The Proposed Longfield Solar Farm Order National Highways Written Representations

Planning Act 2008
Infrastructure Planning (Examination Procedure) Rules 2010

August 2022

**Figure 5: Proposed Order limits Access Arrangements (Construction Phase)**

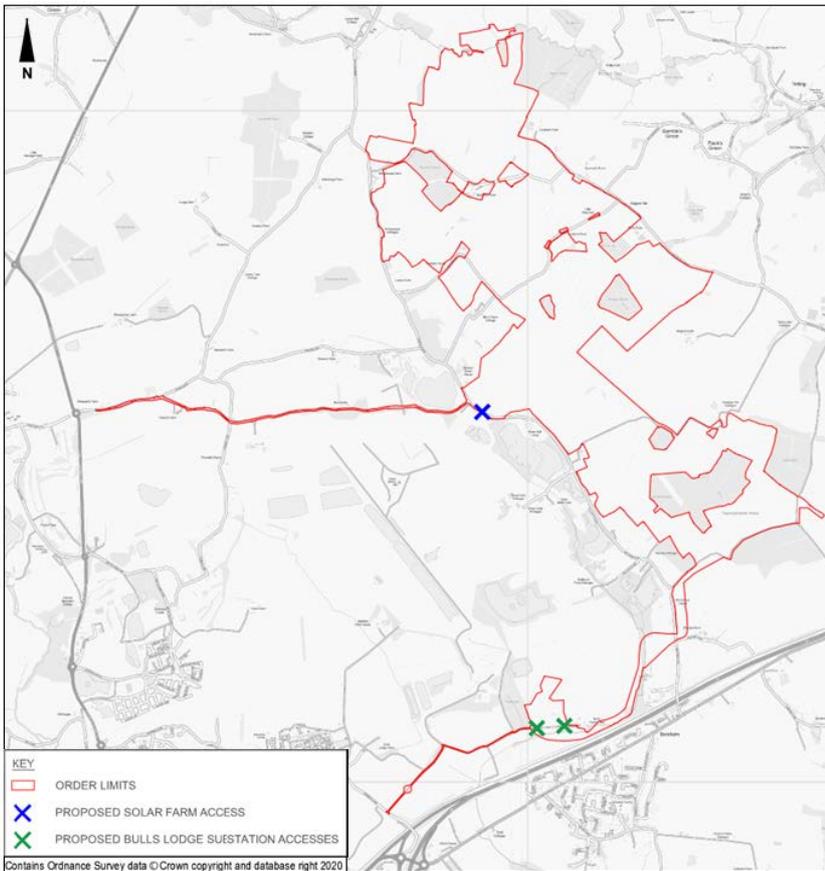
6.4 As mentioned in the Framework CTMP and shown in 'Appendix B – Surrounding Highway Network', LSF proposes to utilise a private road via Boreham Interchange/RDR for Bulls Lodge Substation compound and construction. Plate 2 shows the location and extent of the private road in question.

National Highways require to understand how the maintenance and liability for the use of this private road will be apportioned and agreed between the parties.
